Application no: **3/2021/0556**

Address: **74 Higher Road Longridge PR3 3SY and land to the rear**

Proposal: **Application for reserved matters consent (appearance, scale, landscaping and layout) pursuant to outline planning consent (ref 3/2016/1082) for the demolition of 74 Higher Road and construction of up to 123 houses on land to the rear.**

The Local Highway Authority have viewed the plans and highway related documents and have the following comments to make:

ILLUSTRATIVE SITE SECTIONS - SHEET 1 OF 2

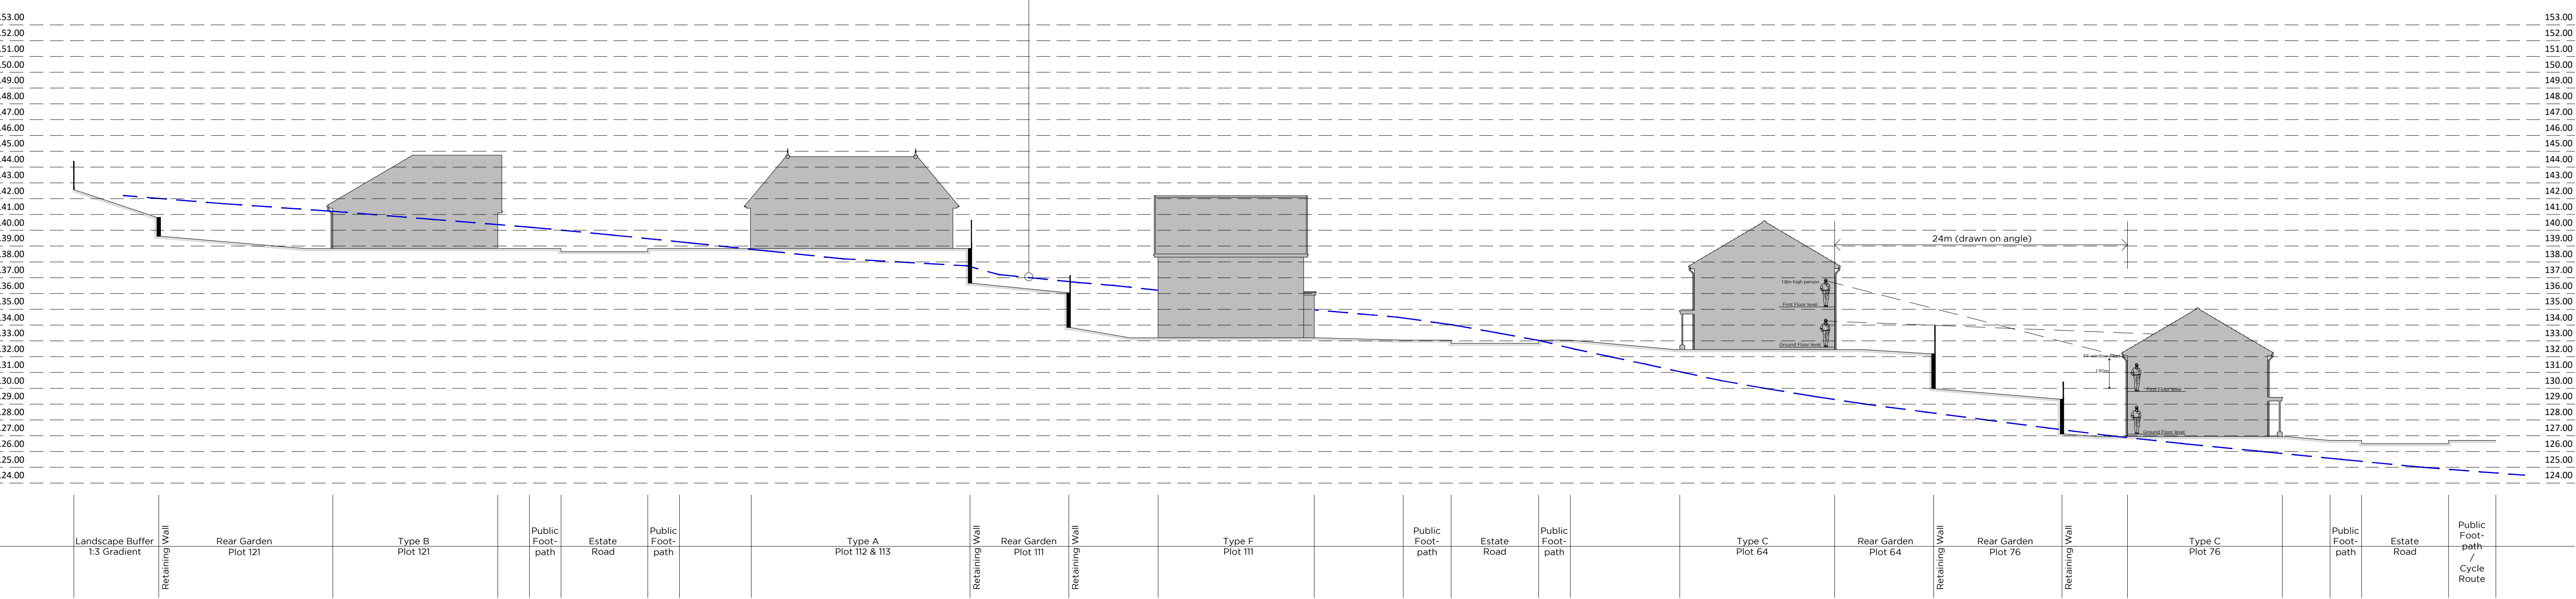
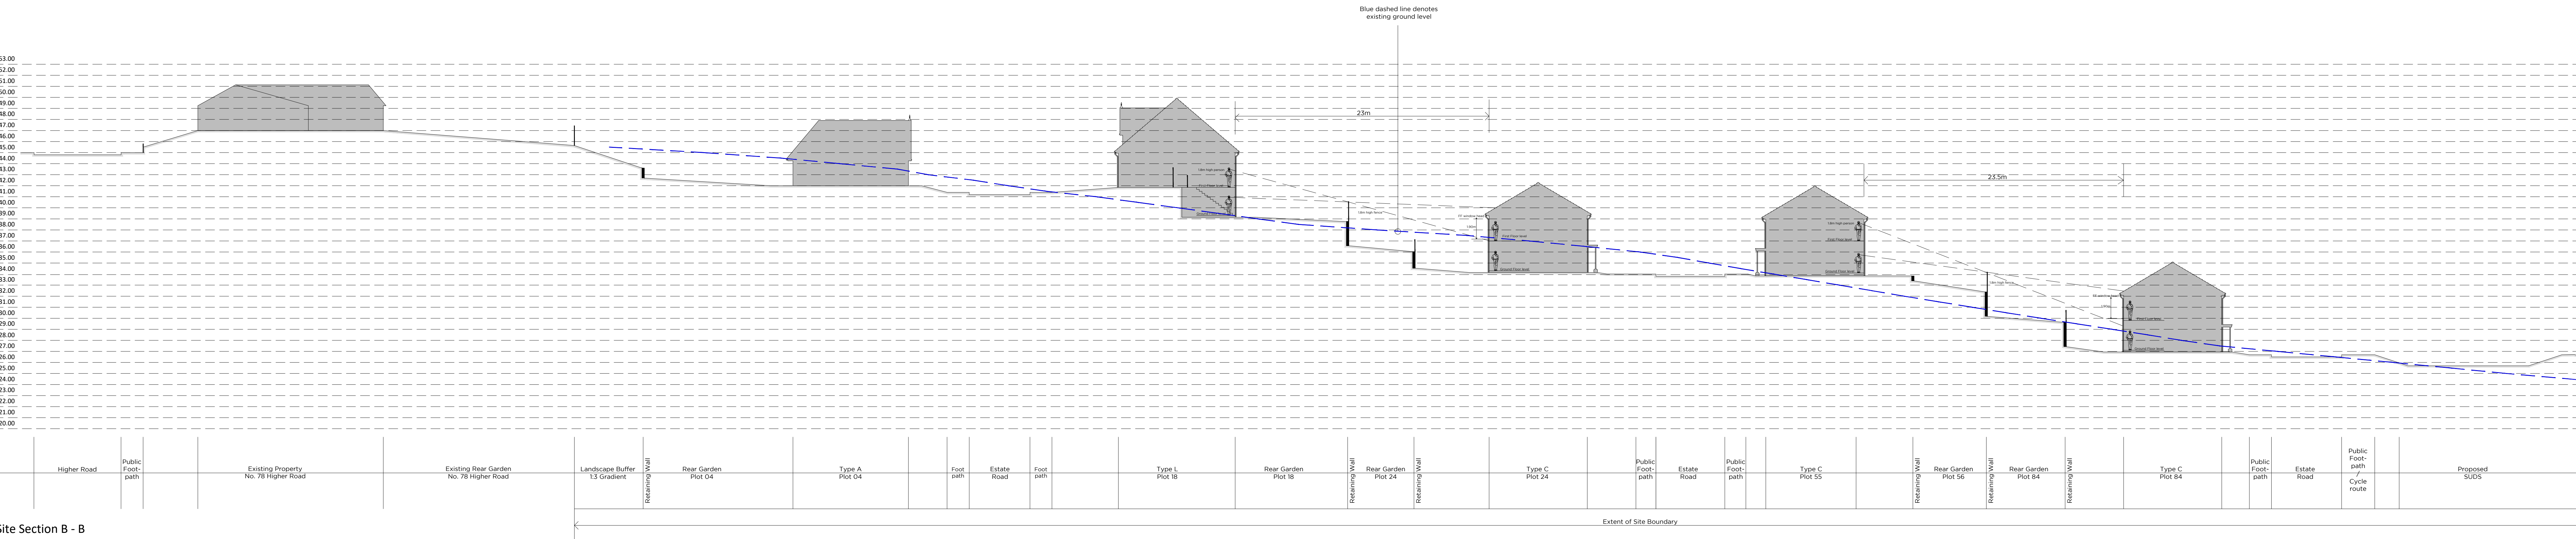
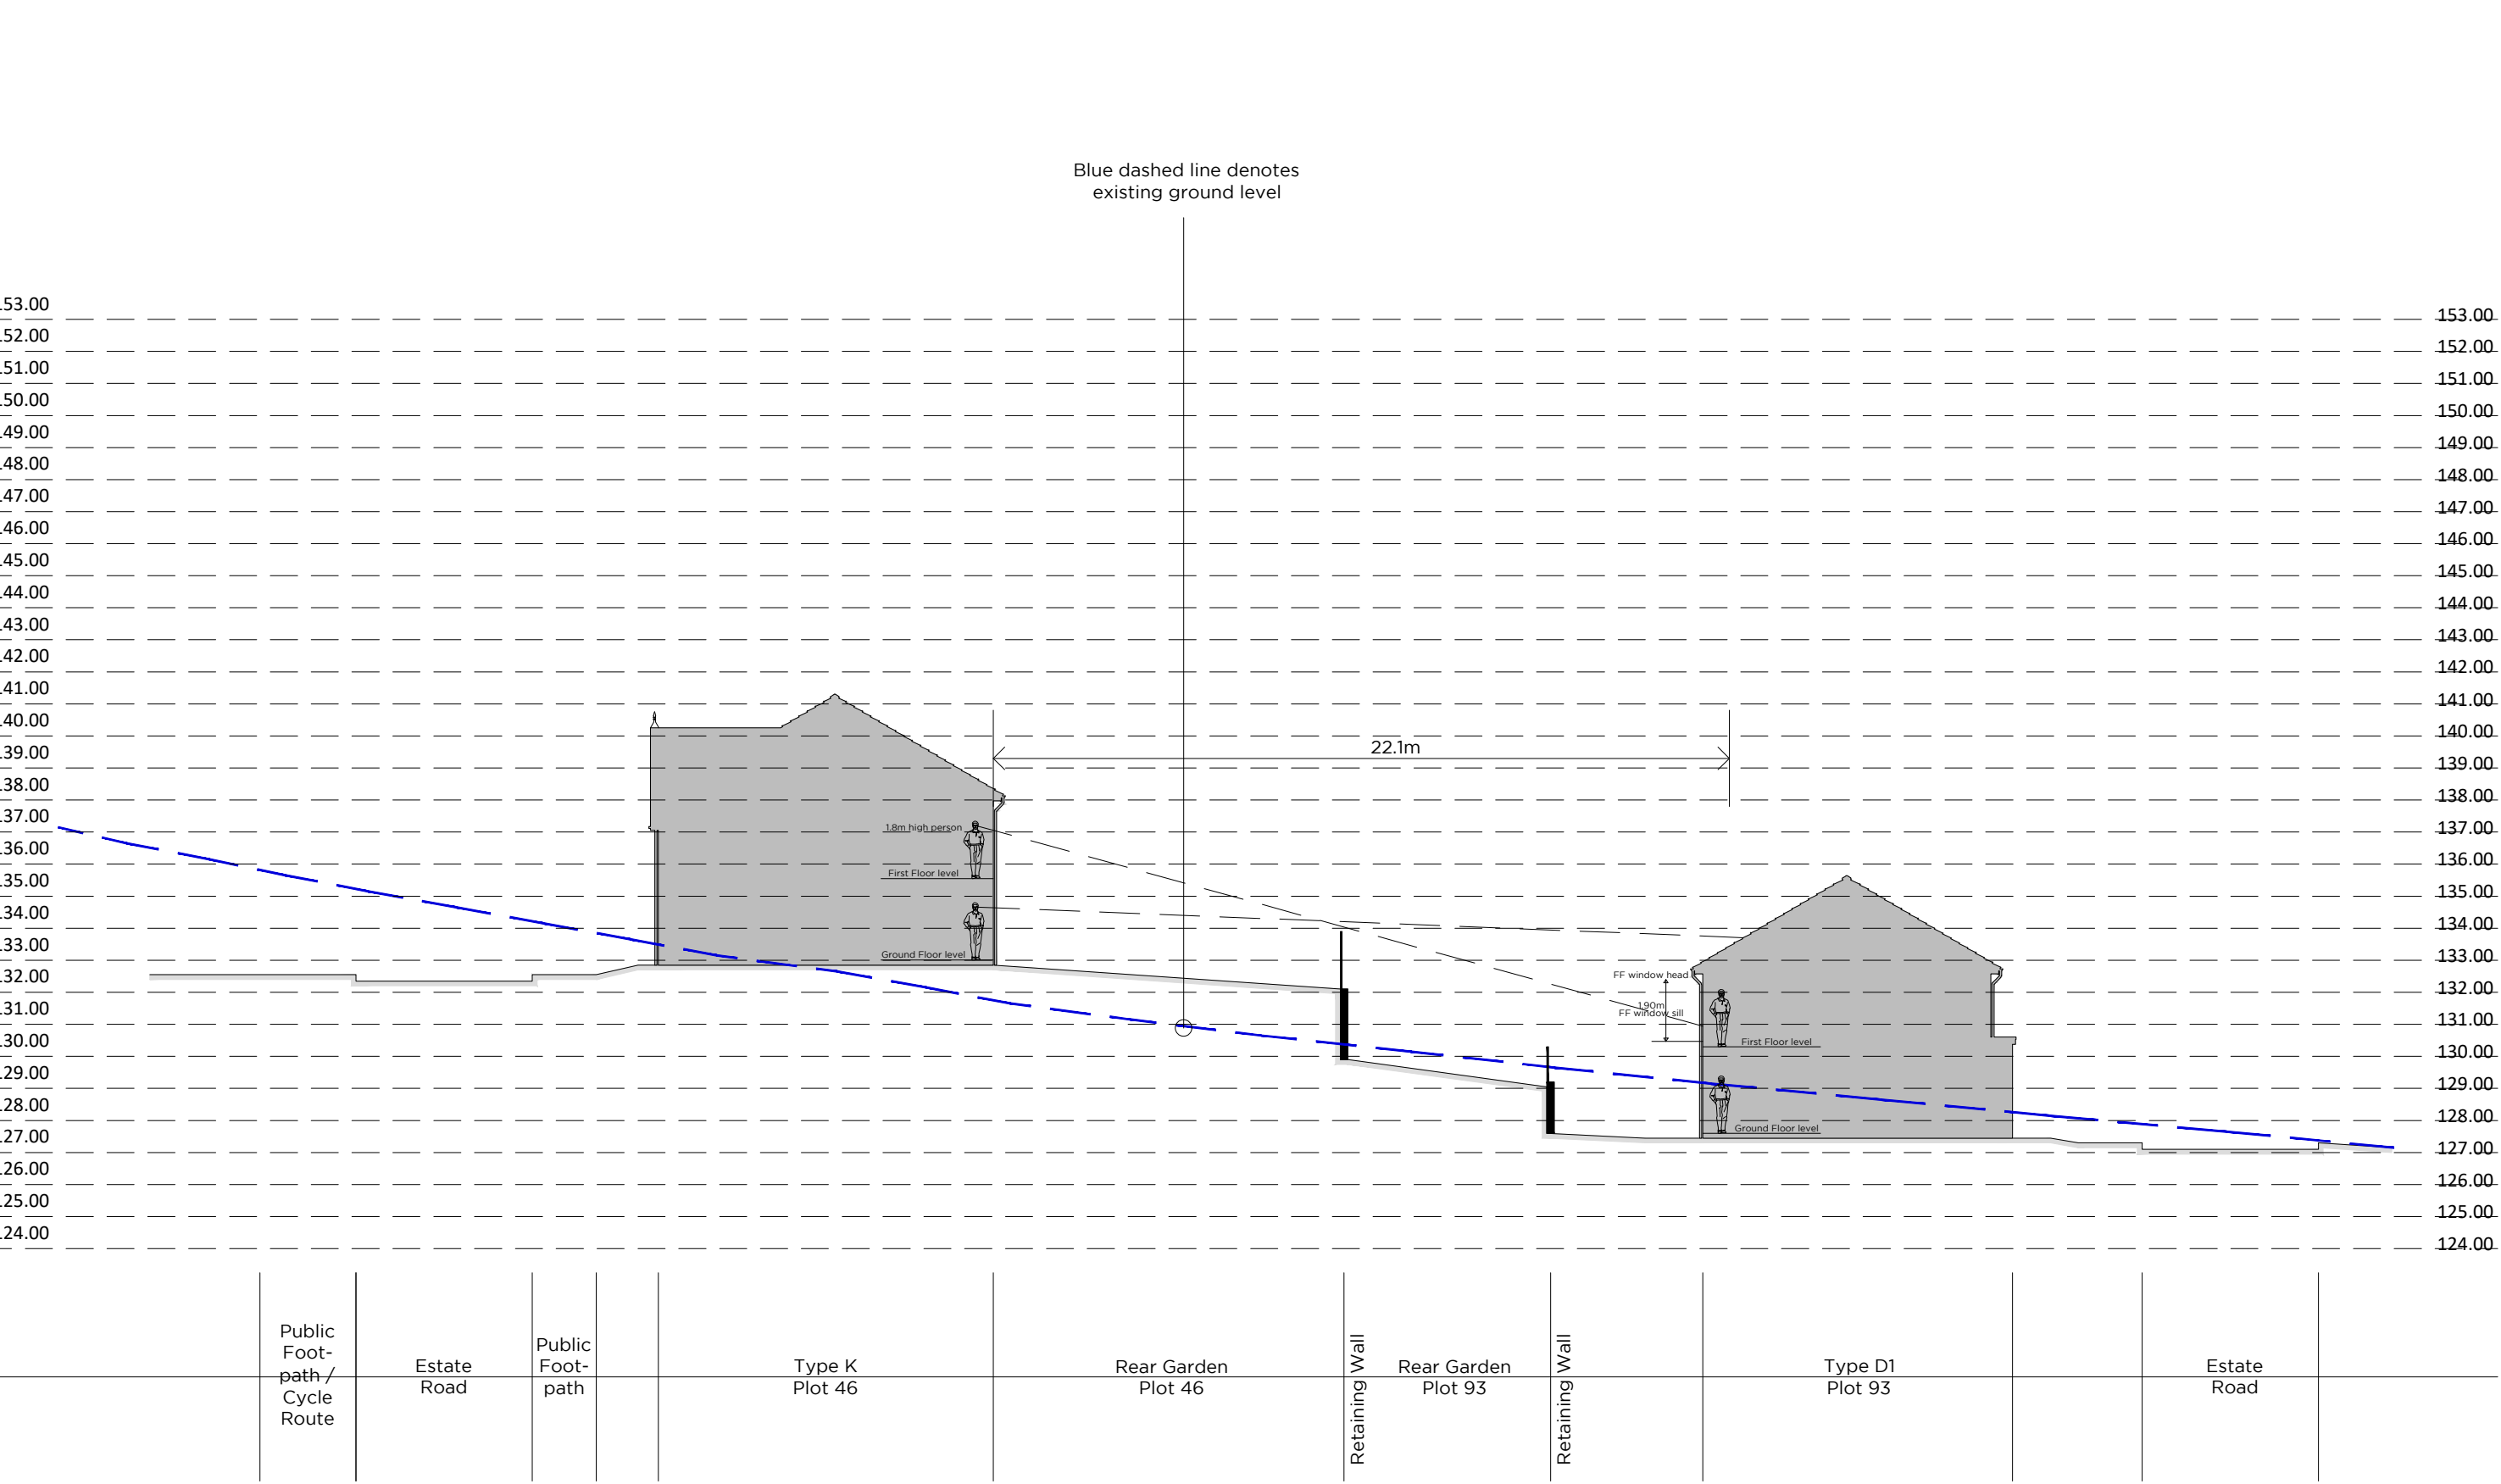
Due to the gradient of the site, the LHA require further site sections. These site section should be of the two attenuation basins, as shown on the drawing.

The LHA also require long sections of the gradient along the curve in the road close to Plots 71 and 72. The drawing should show the kerbs and the public highway.

A gradient of less than 1 in 12 is acceptable, with the maximum gradient the LHA accept is 1 in 10.
